From: Laura Gibbons
Sent: 06 December 2018 15:06
To: Planning.Responses
Cc: Michael Eastham
Subject: RE: Planning Consultation on LU/283/18/DOC

Engineers Comments Regarding Condition 8- surface water drainage scheme

APPLICATION LU/283/18/DOC
NO:

Registered: 27-SEP-18
Site Address: Kingsley Gate Court Wick Lane Littlehampton BN17 7DE

Title COMMERCIAL UNIT & CHANGING FACILITIES DRAINAGE LAYOUT

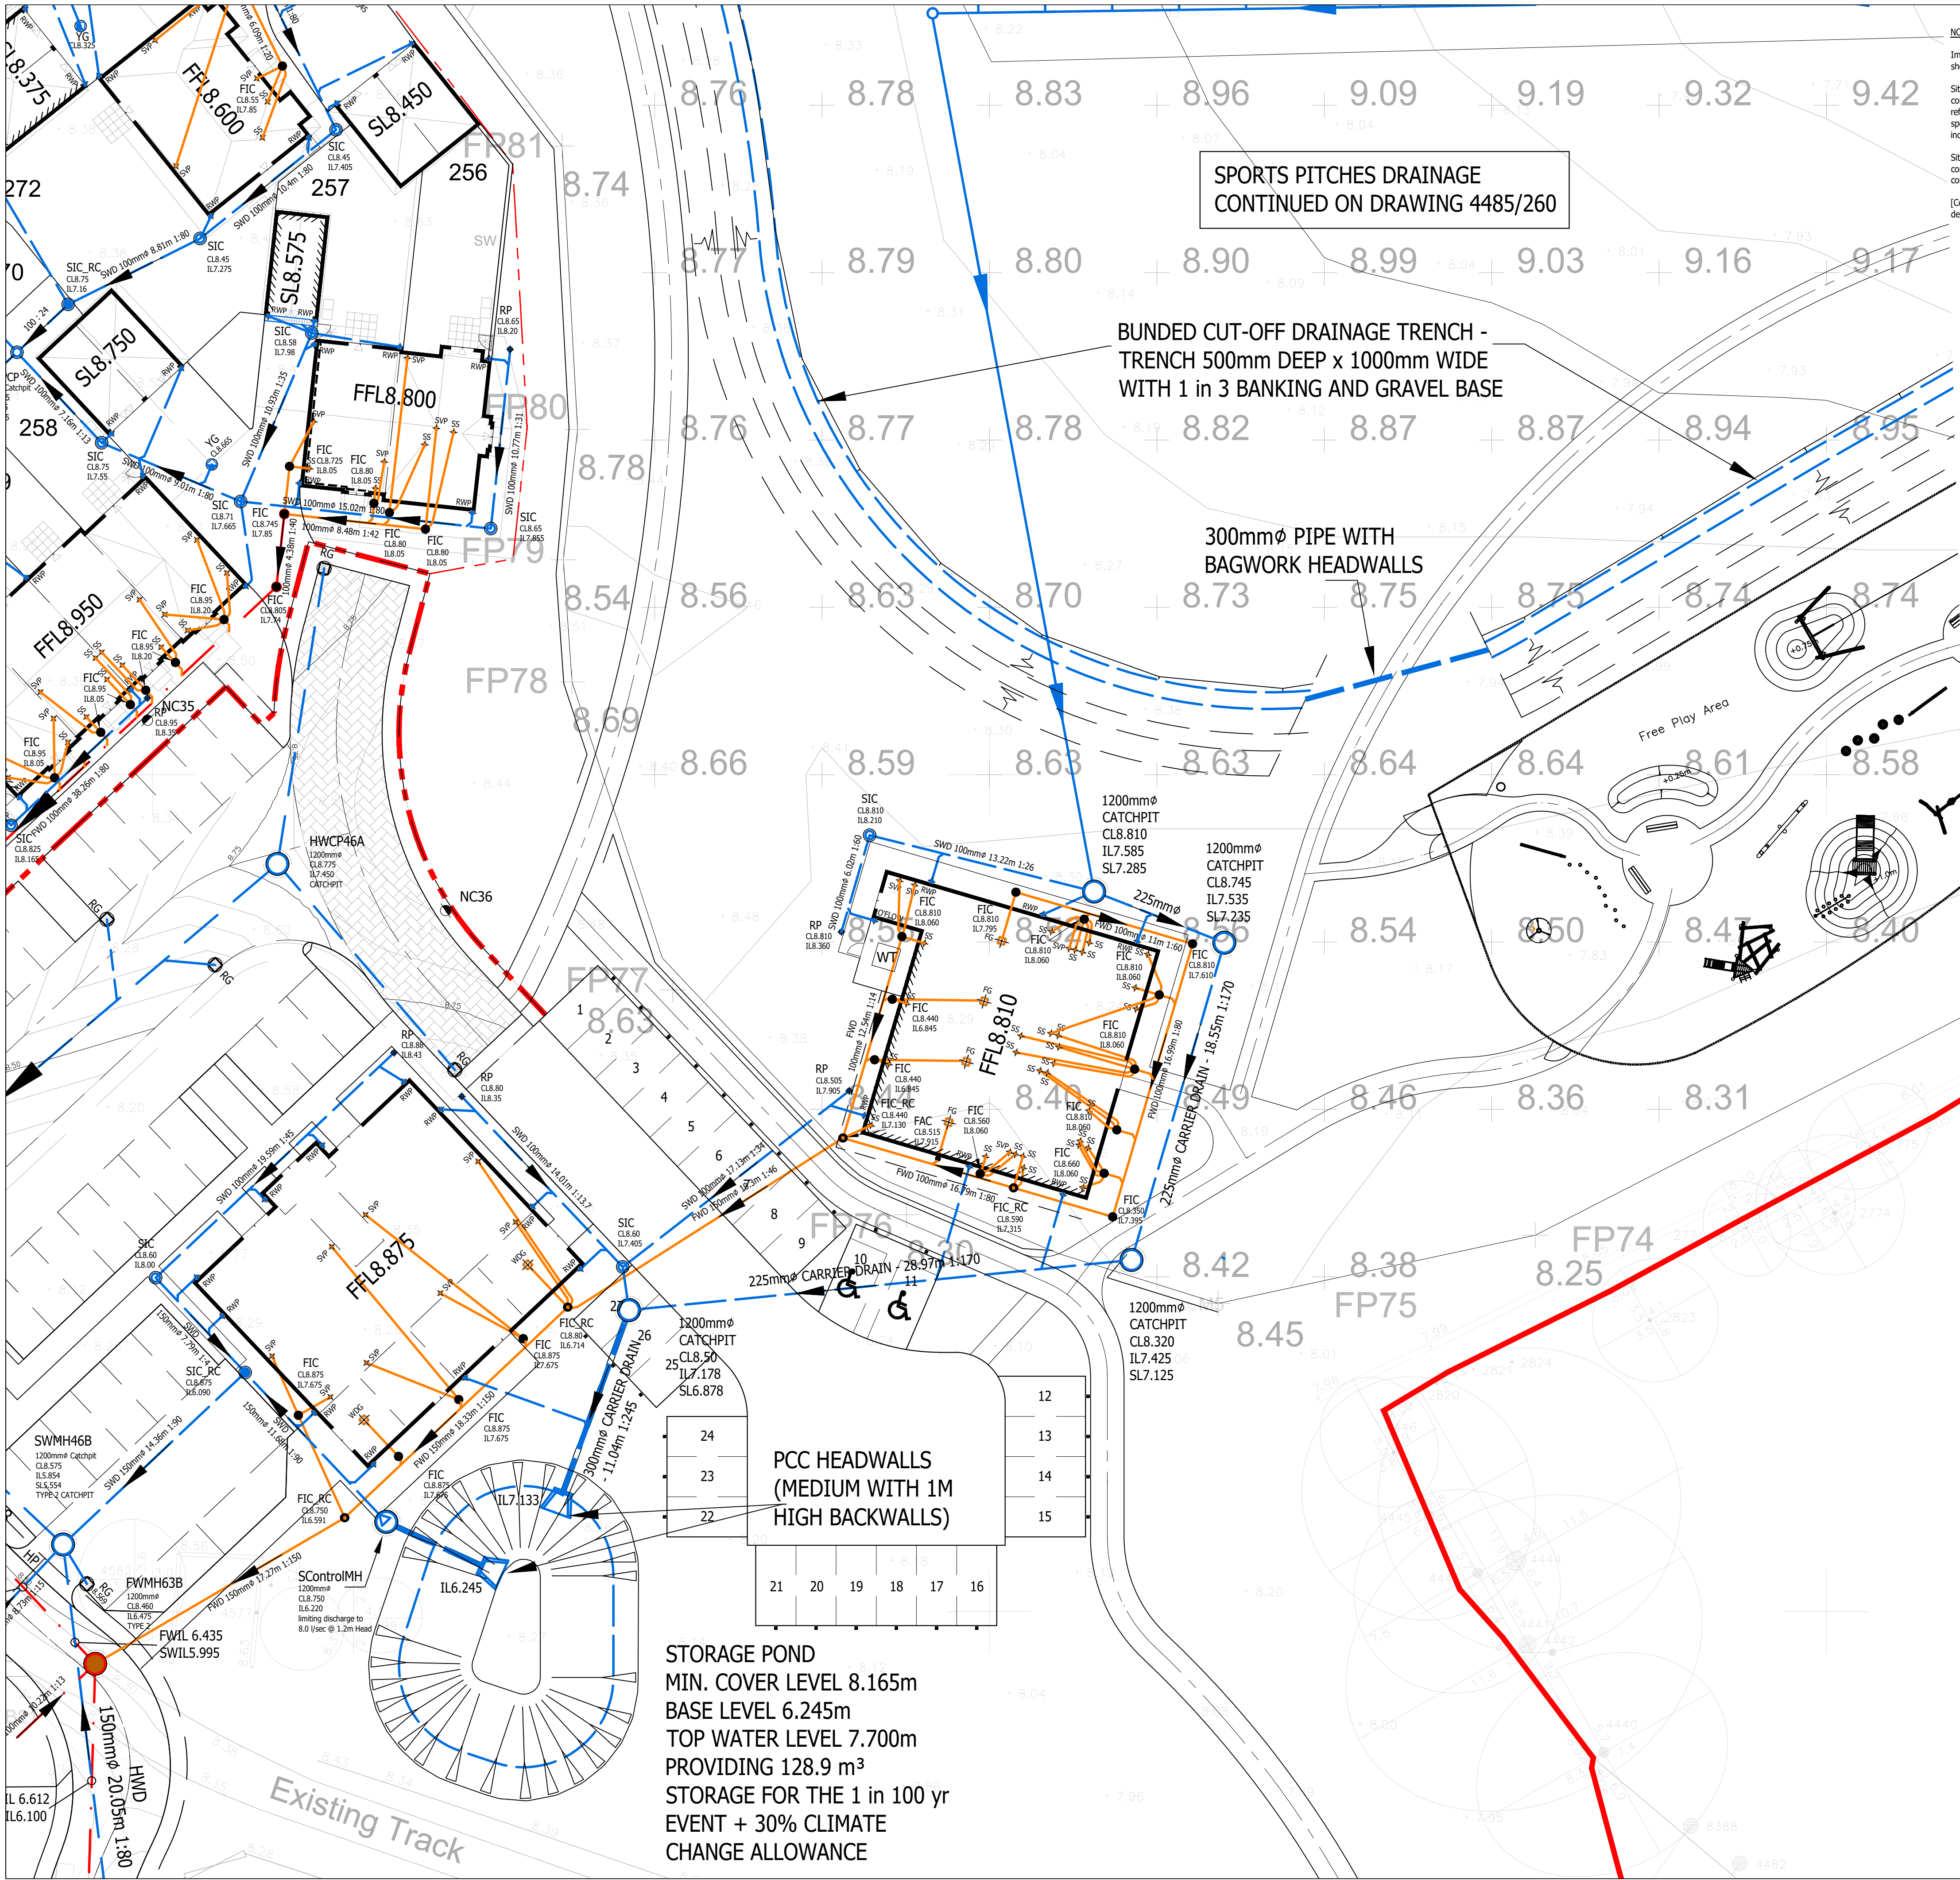
A Drainage layout plan has been provided. But no supporting information, calculations or construction details have been submitted. It is not possible to review the adequacy of the drainage design without this. Please submit a complete application.

Until these details are provided I cannot recommend the discharge of condition 8.
